ENG-PUDSP21010-R5-PDR.pdf Markup Summary

What are the MDDP flows at DP 34 -- 413 cfs? FEMA flows account for (~1.5 sq mi) at then-existing conditions. Meridian Ranch MDDP - DP-G06 1.45 sq. mi., historic Q100=628, developed 663 cfs should be referenced also. See MDDP in SKP-17-1 file.

**PRELIMINARY DRAINAGE PLAN**  
**GRANDVIEW RESERVE FILING NO. 1**  
**FOR**  
**HR GREEN, INC**  
 EASTONVILLE RD  
 EL PASO COUNTY, PEYTON, CO 80831

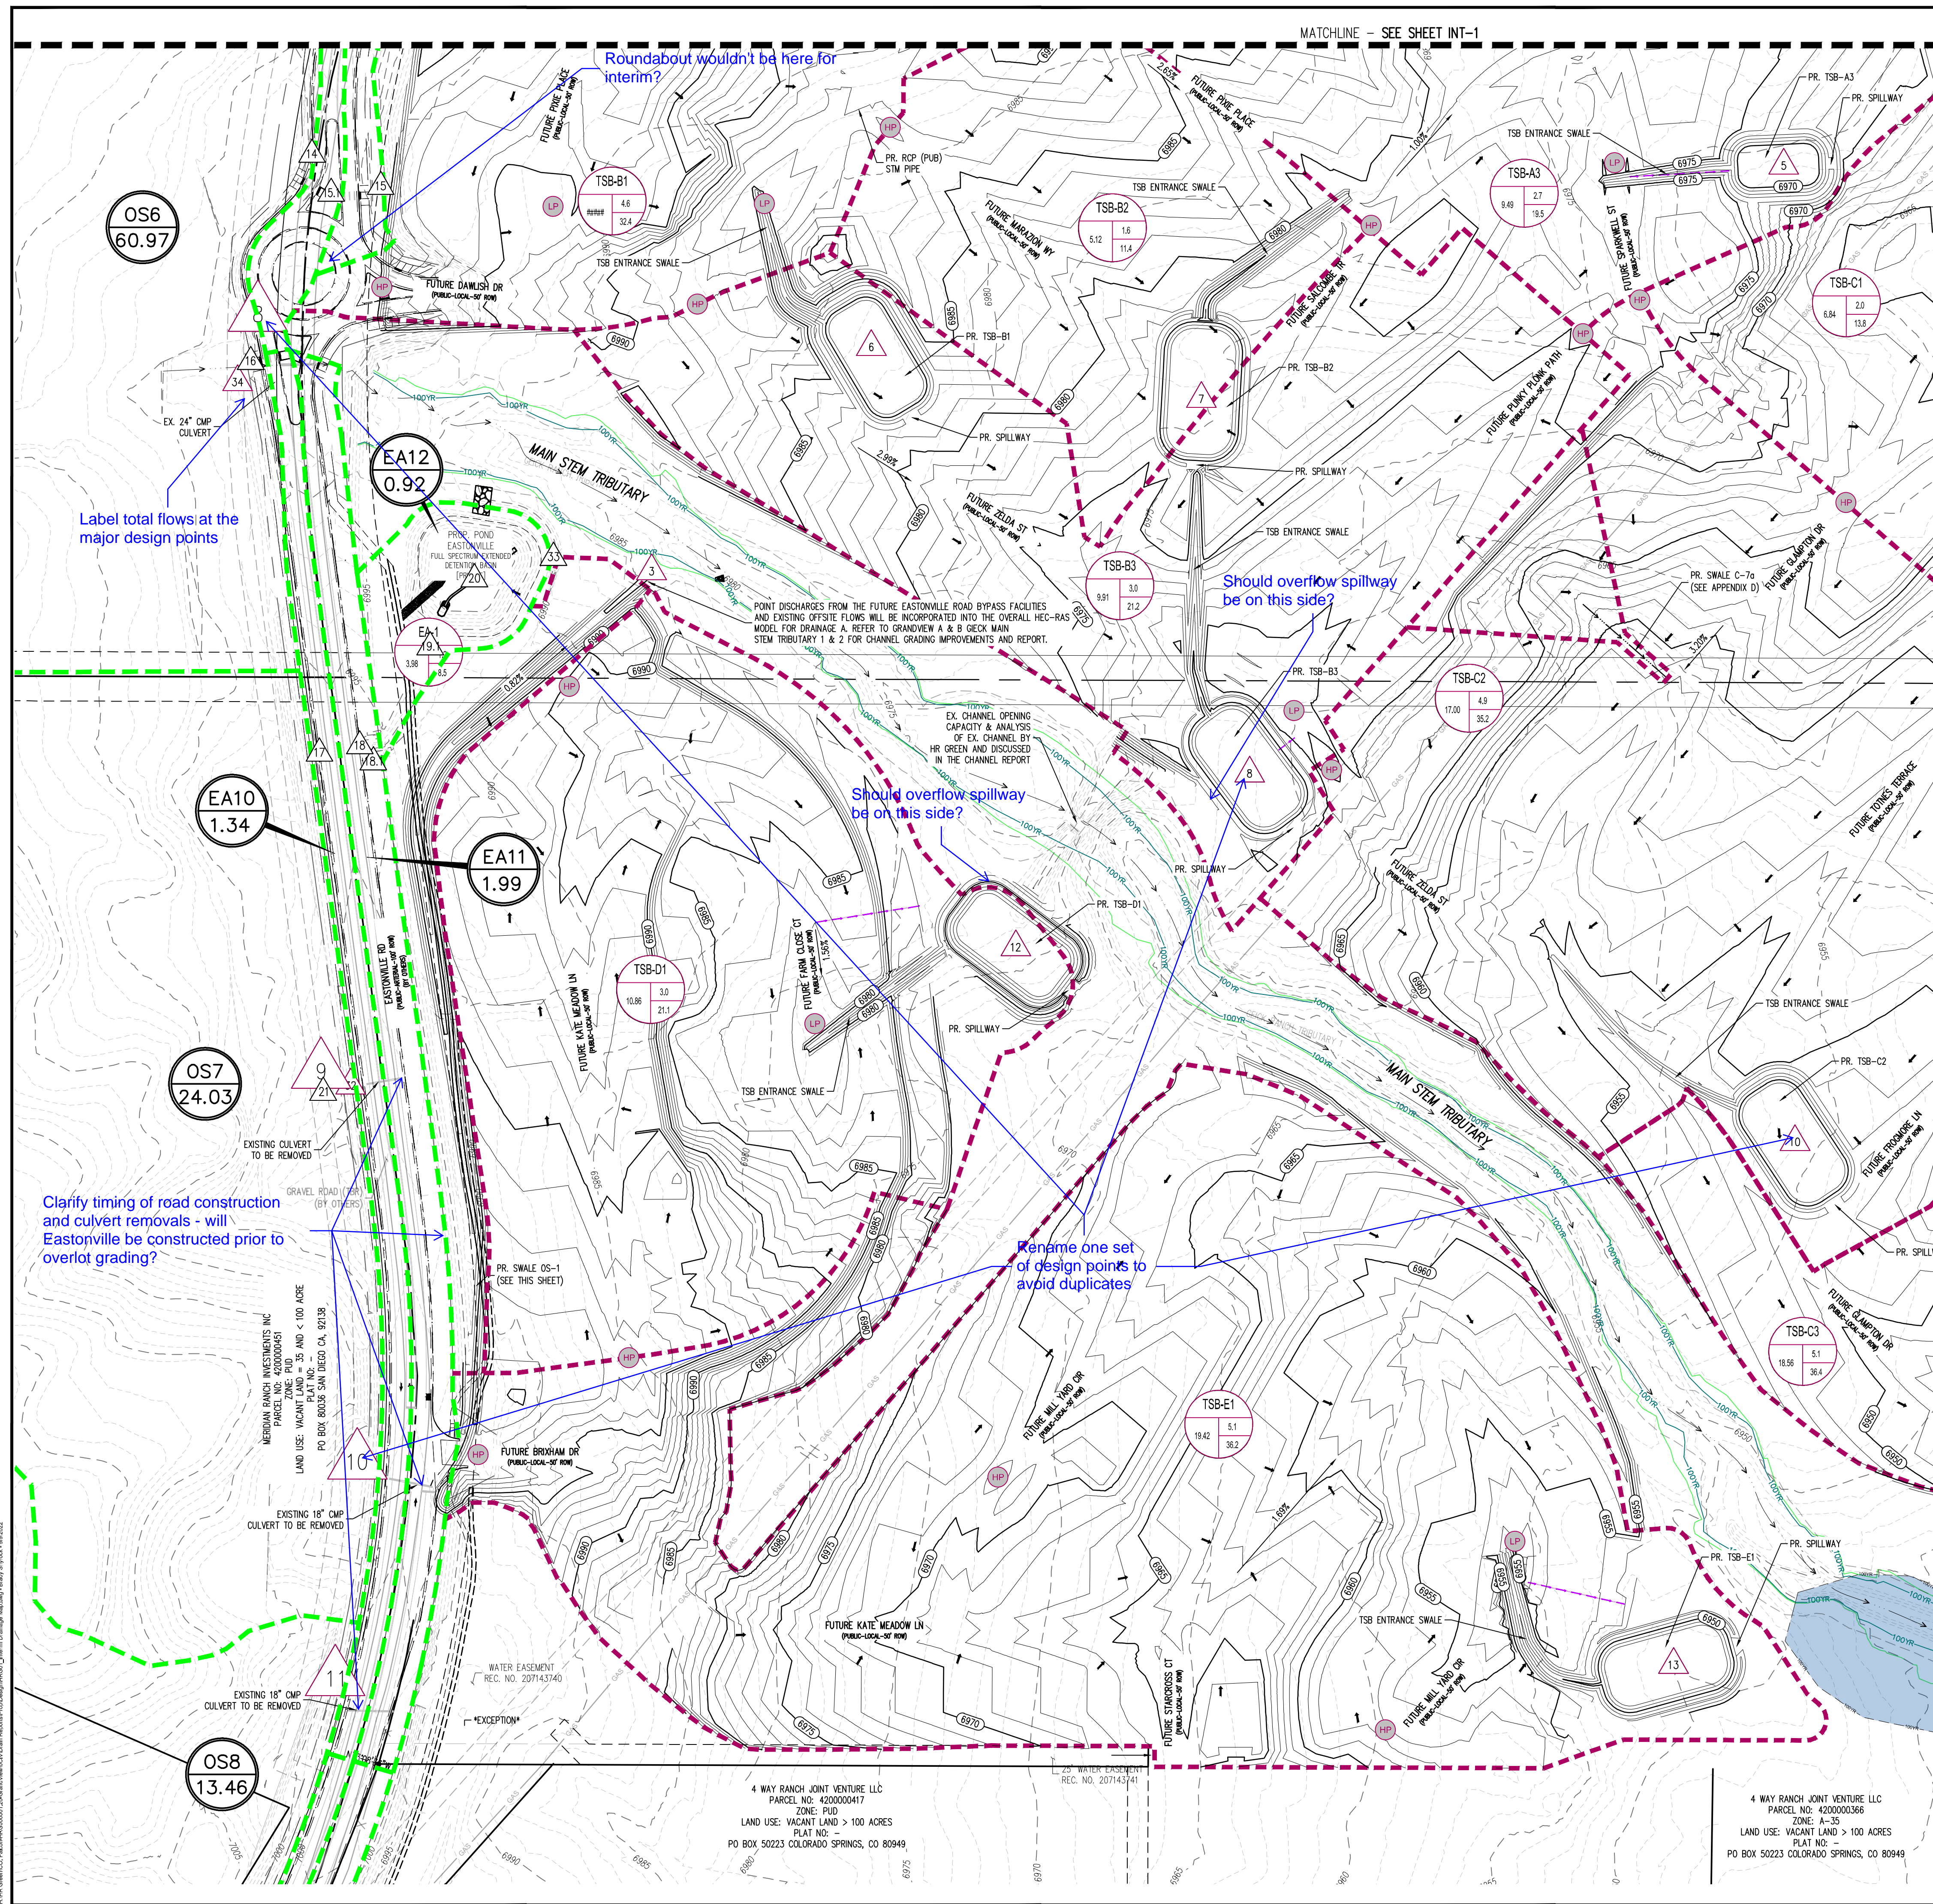
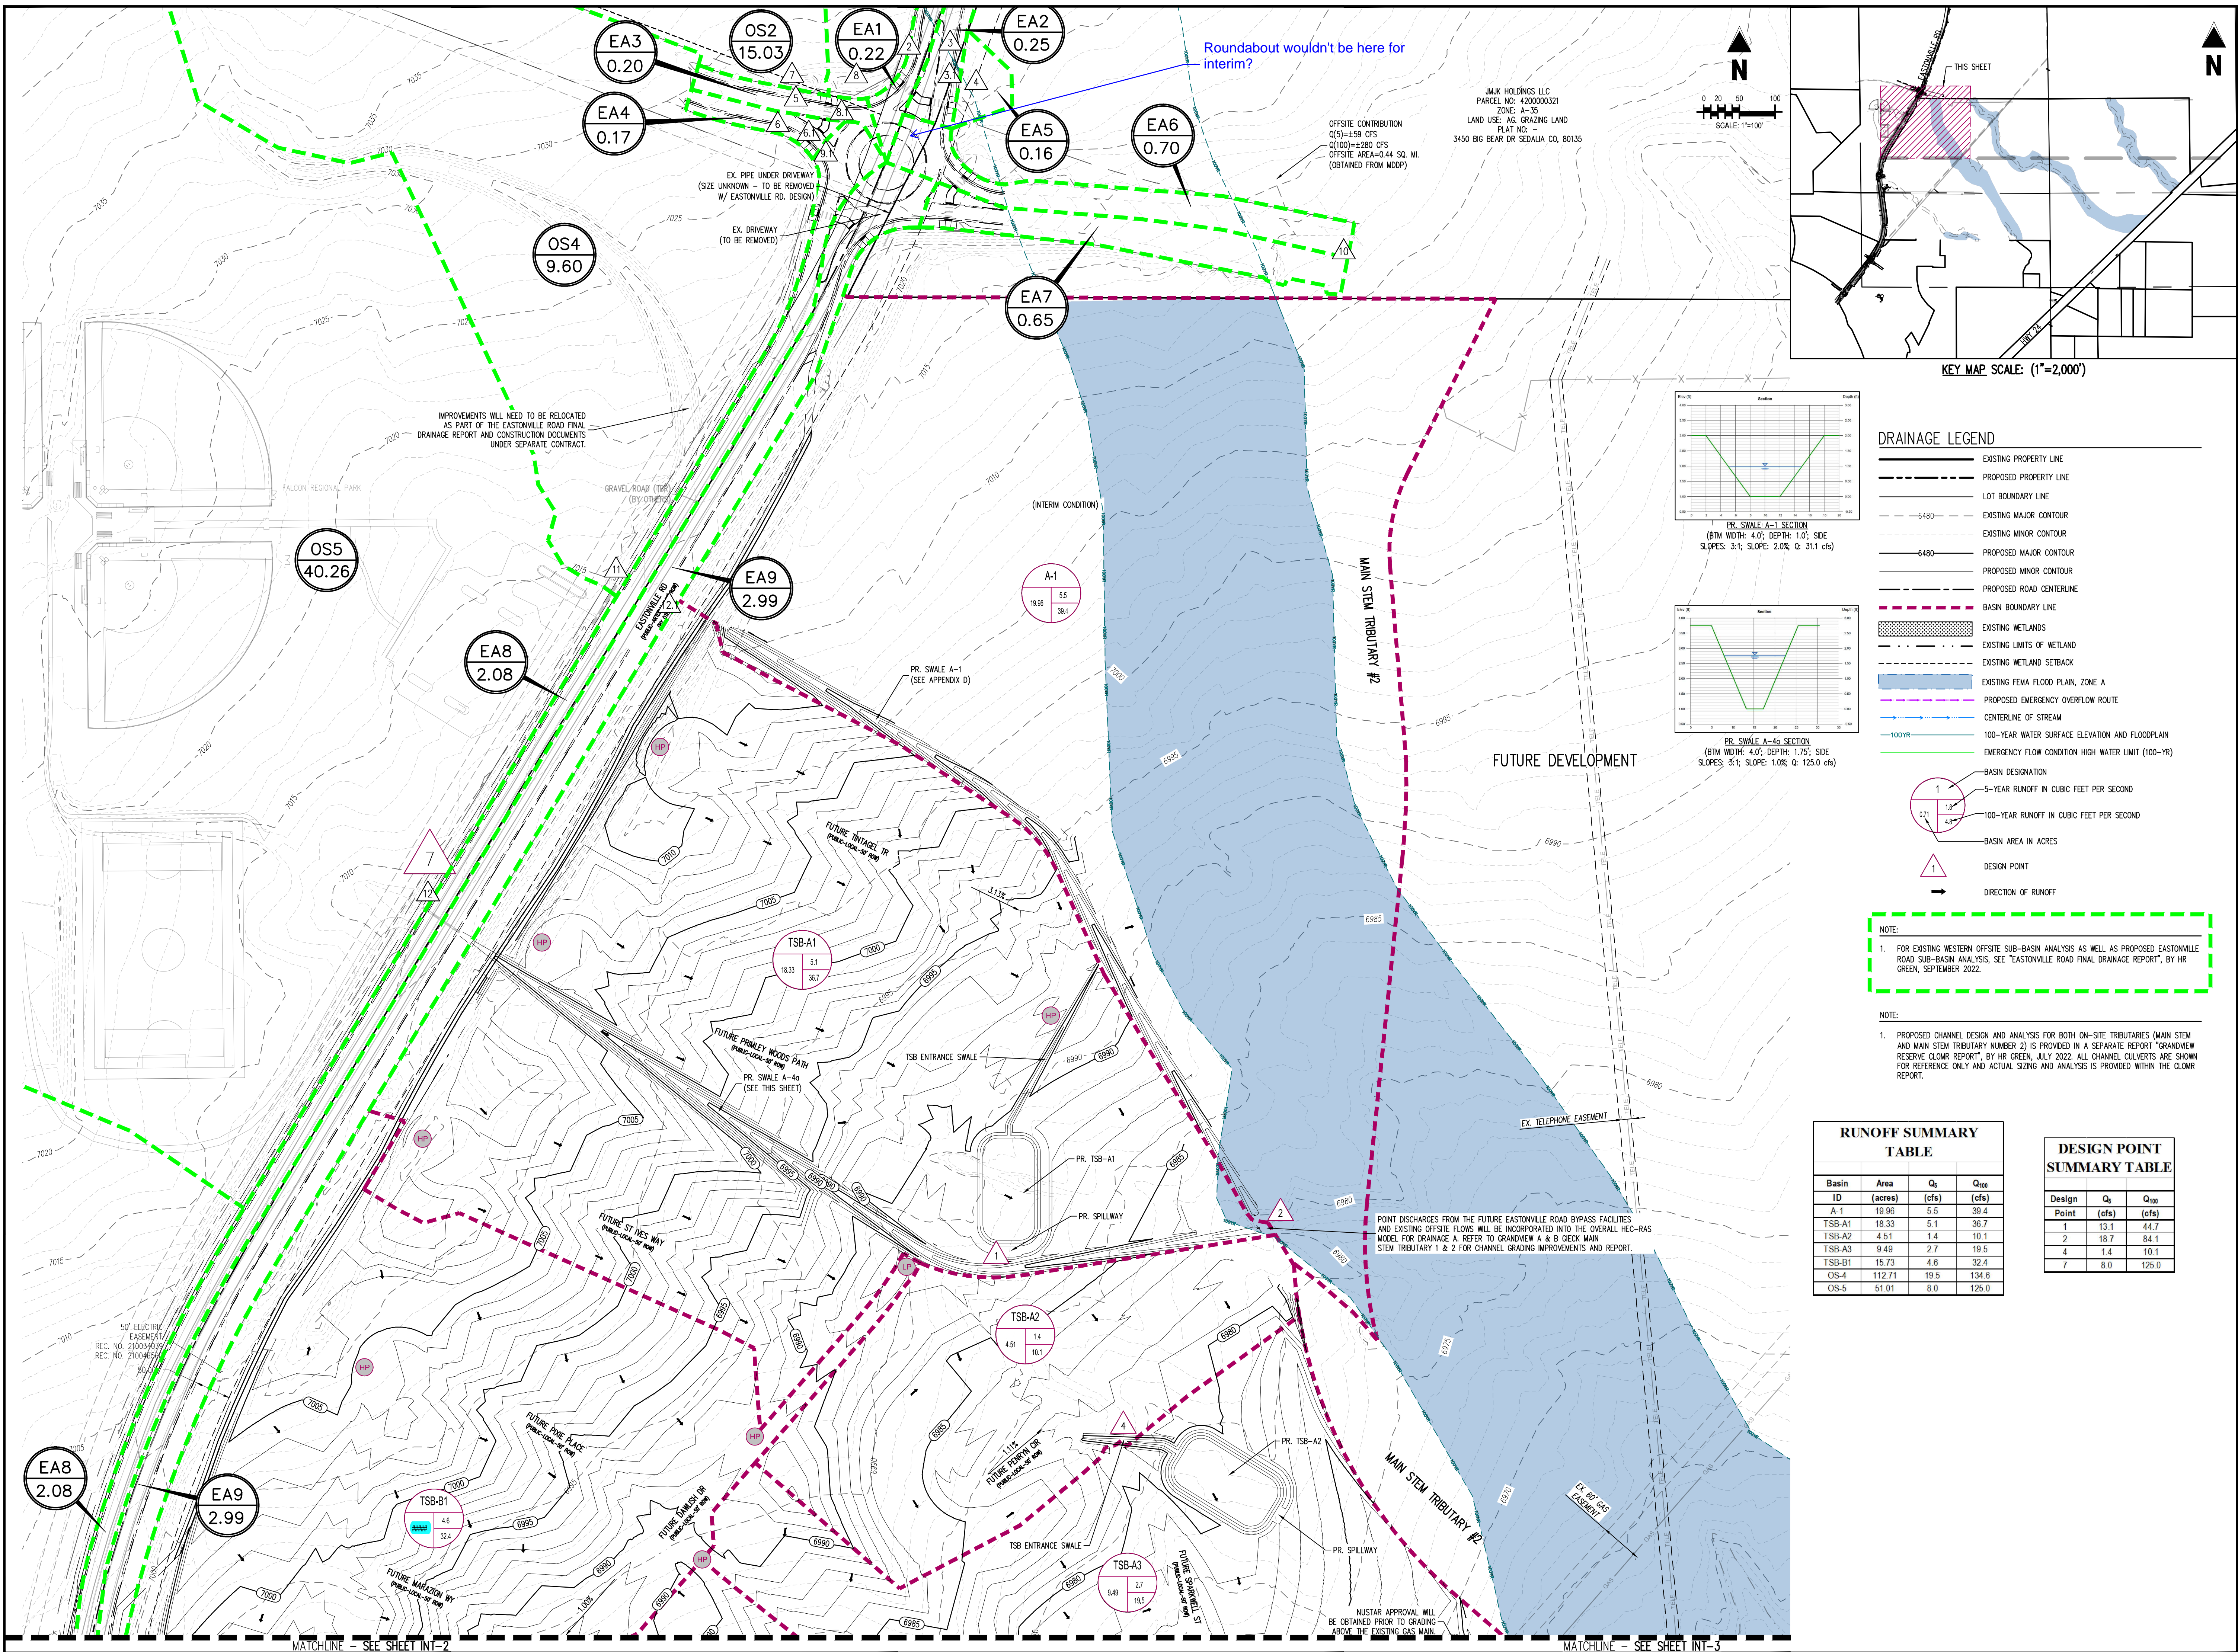
Show and label approximate headwater ponding area

Show and label approximate headwater ponding area

Show and label approximate headwater ponding area. With 628 cfs (8' deep), it appears that flows could be diverted to the south. Verify capacity

Show grading required

Refer to Eastonville Road FDR

Refer to Eastonville Road FDR

Refer to Eastonville Road FDR

Refer to Eastonville Road FDR
